21 June 2018

APA Reference: 20180621_LO_438443_Sutton Forest Quarry

RE: **Proposed development of Sutton Forest Quarry**
State Significant Development Application Number SSD6334

QUARRY ACCESS ROAD LAYOUT

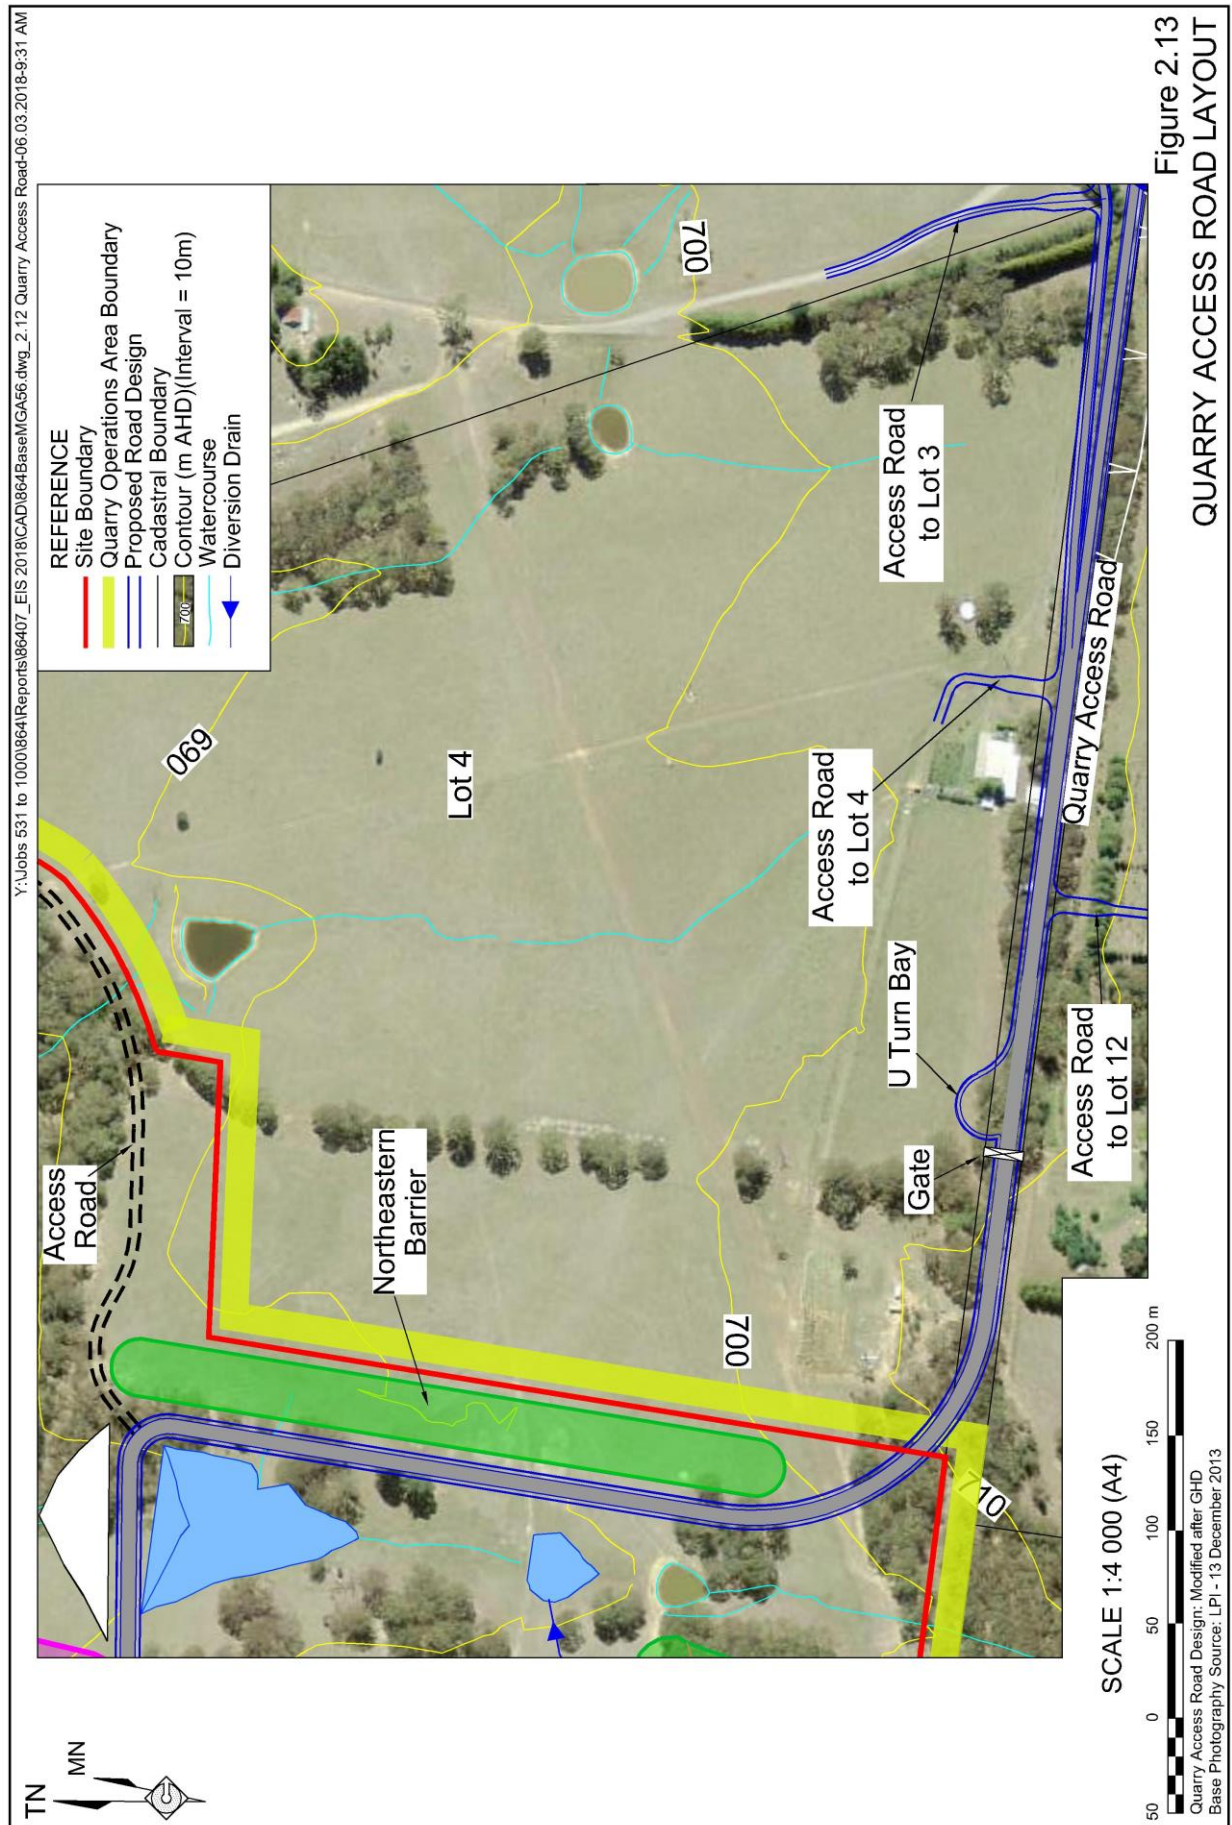
The EIS does not directly address the fact that the proposed quarry access road will cross APA's pipelines (s2.4.5). However, the Traffic Impact Assessment does recognise the road will need to cross the pipelines and require a "suitably designed concrete slab". Under State legislation APA authorisation is required for such a crossing and such crossing must be designed with protective slabbing to APA's requirements to ensure the pipeline is not damaged by the frequent movement of heavy vehicles. Such crossing would also need to be designed to maintain adequate depth of cover over any part of the pipeline which is not slabbed.

The proposal also anticipates the need for connection of power and telephone services (s.2.9) which may need to cross APA's pipelines, which again requires our authorisation. Such crossing and authorisation is not anticipated by the EIS. Details of all proposed crossings, and works within the easement, must be submitted to APA for consideration. No crossings or works may occur without the prior authorisation of APA, and must be completed in accordance with any conditions imposed by APA.

2. Road Crossings Engineering Plans

Detailed engineering plans for any proposed road crossings over the gas transmission pipeline easement must be submitted to APA for consideration. Works may only proceed under APA Third Party Works Authorisation, and subject to any conditions of the Authorisation.
